Application for a minor material amendment to Planning Permission 21/03347/FUL (as already amended by 22/02041/S73).

Proposal: Demolition of existing dwelling and outbuildings. Erection of a replacement dwelling and outbuilding together with associated works and landscaping.

At: East Lodge The Green Kingham Chipping Norton

Project Address	East Lodge, The Green, Kingham, OX7 6YD		
Project Description	Proposed Dwelling		
Drawing Title	Proposed Site Plan		
Drawing No.	2662-1100	Rev.	I

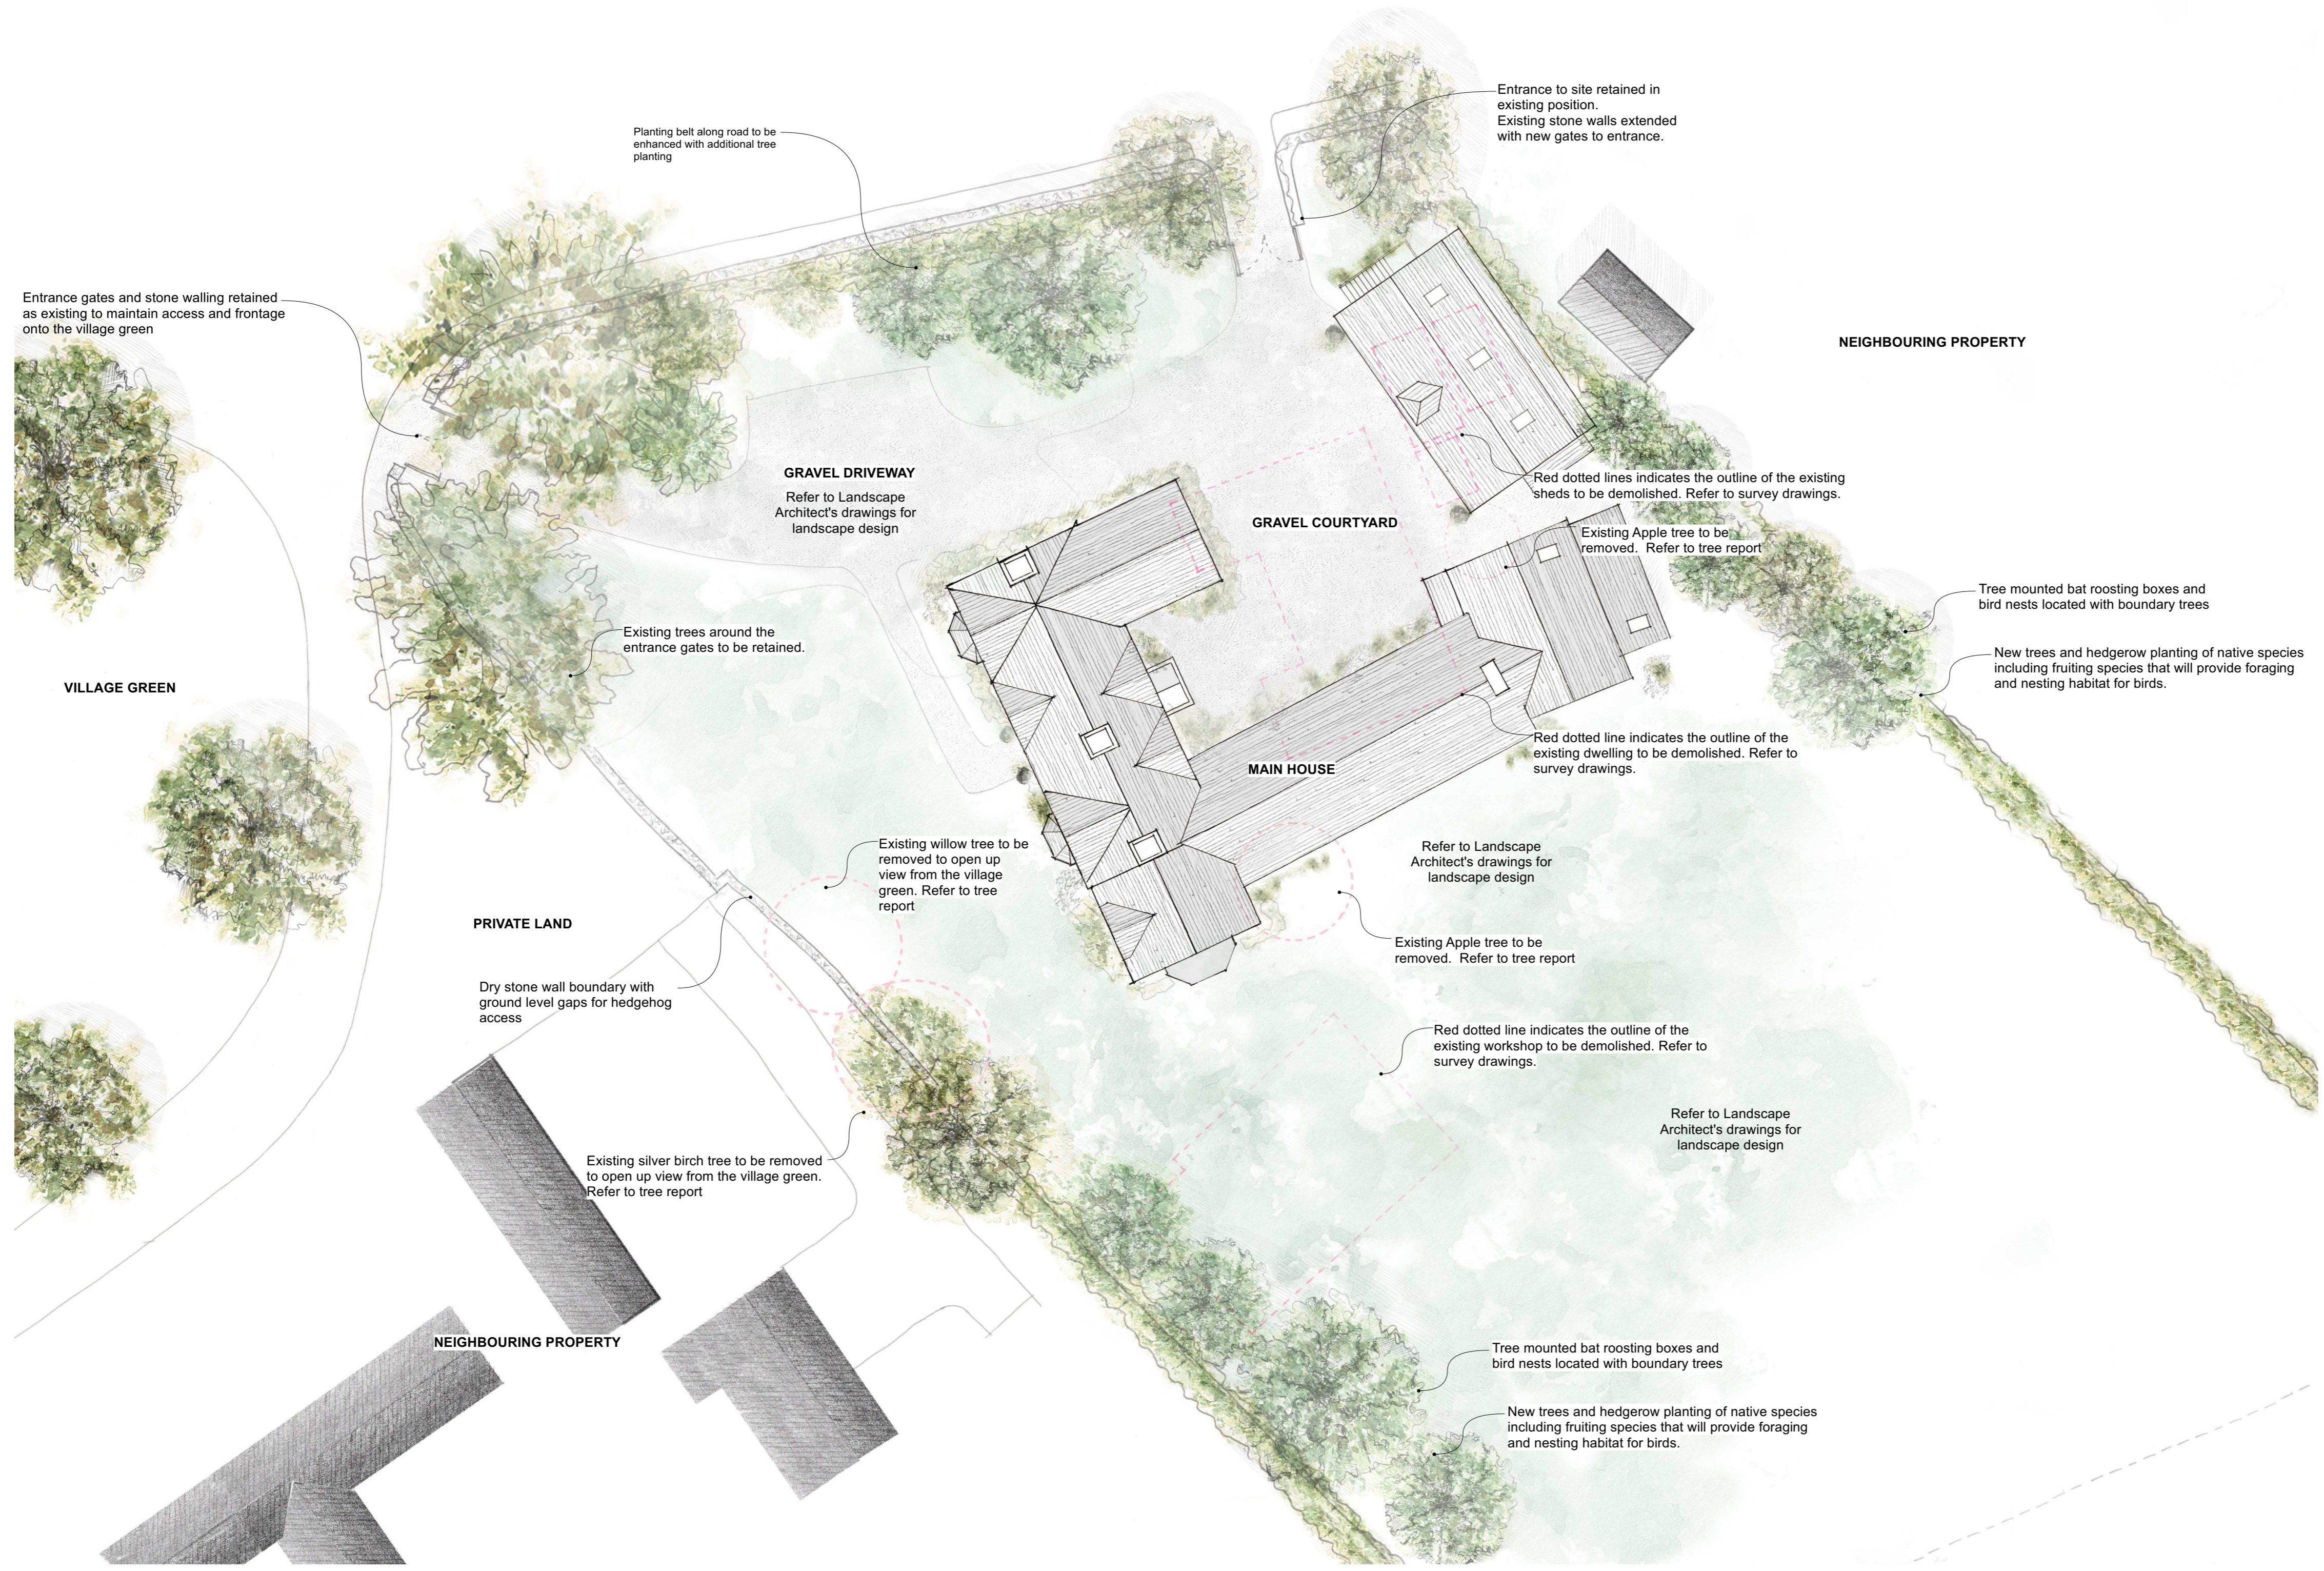
This would replace revision F (as previously amended) and is altered with a slightly longer east facing wing at the northern end of the dwelling, the inclusion of a lean-to bin store on the garage building and bat and bird boxes indicated in retained trees. Slightly extended walls are shown at the eastern site entrance. The roof material for the garage is changed from those reclaimed from the dwelling to reconstituted stone slate to match the remainder of the buildings.

Project Address	East Lodge, The Green, Kingham, OX7 6YD		
Project Description	Proposed Dwelling		
Drawing Title	Proposed Elevations_1		
Drawing No.	2662-1120	Rev.	G

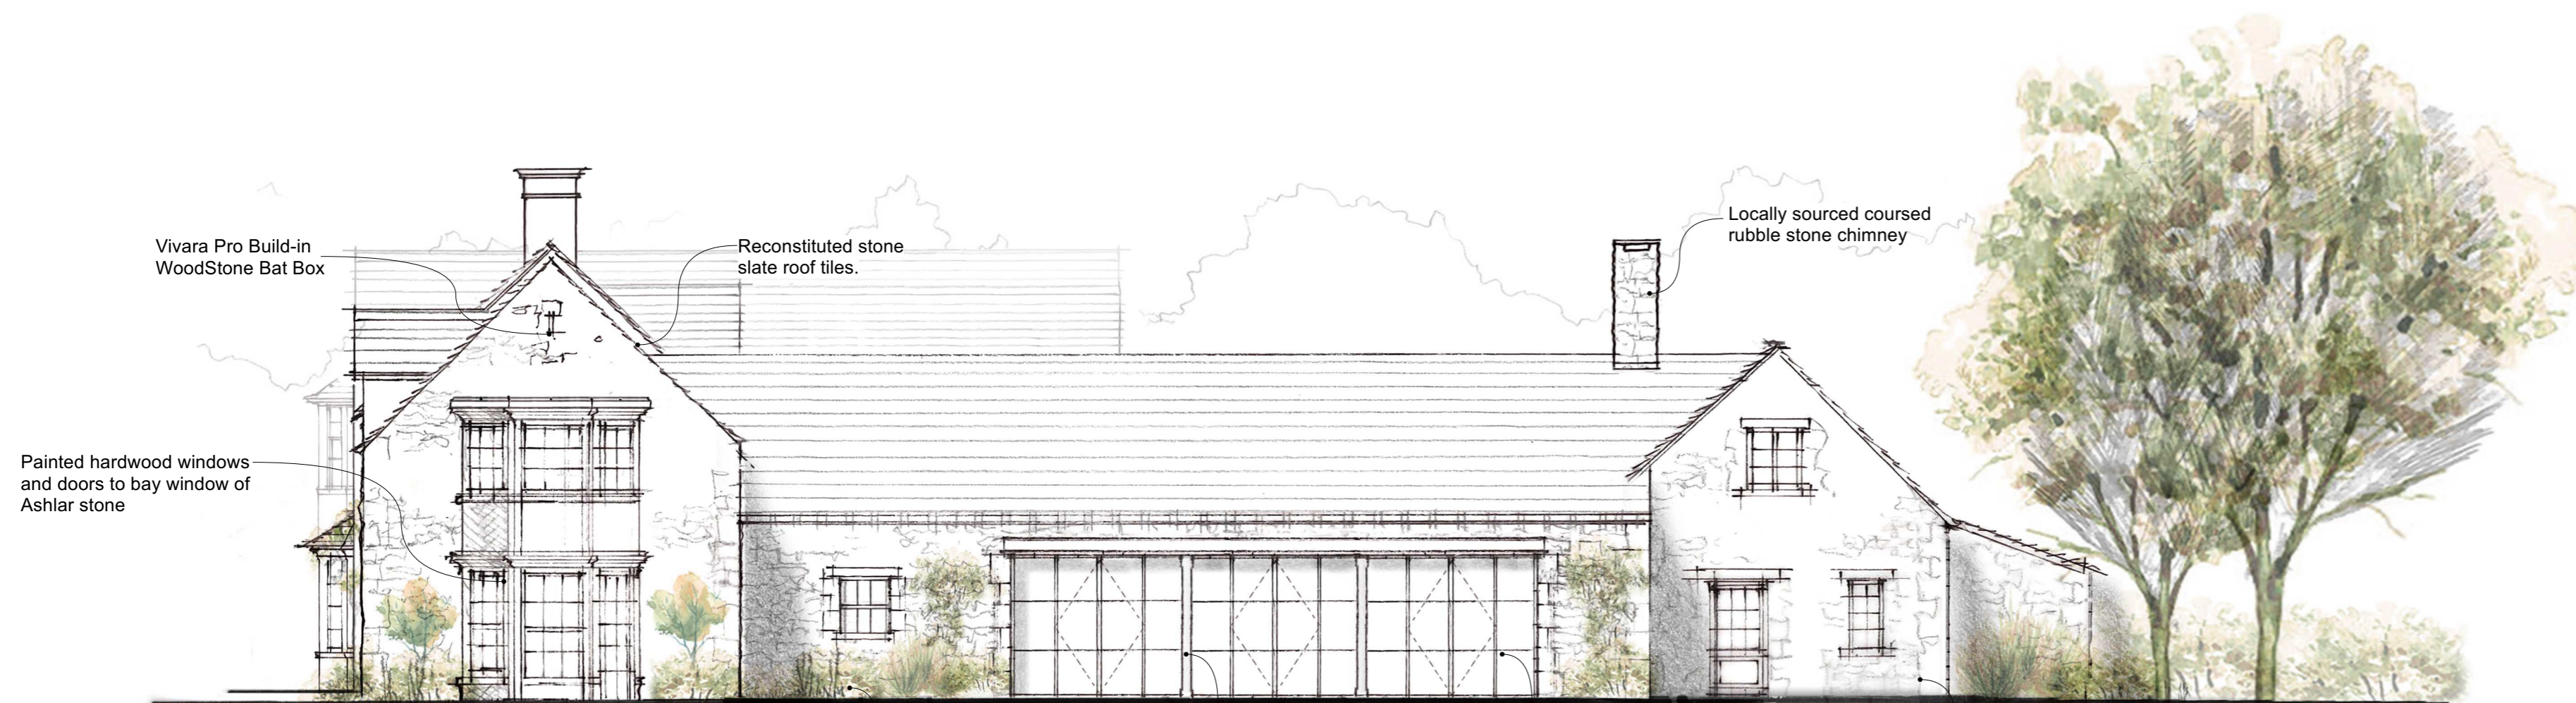
This would replace revision D. It shows the revised door arrangement to the south elevation from the sitting room and includes an image of the sample roof material (condition 9) and to include details of the ecology mitigation for conditions 7 and 11.
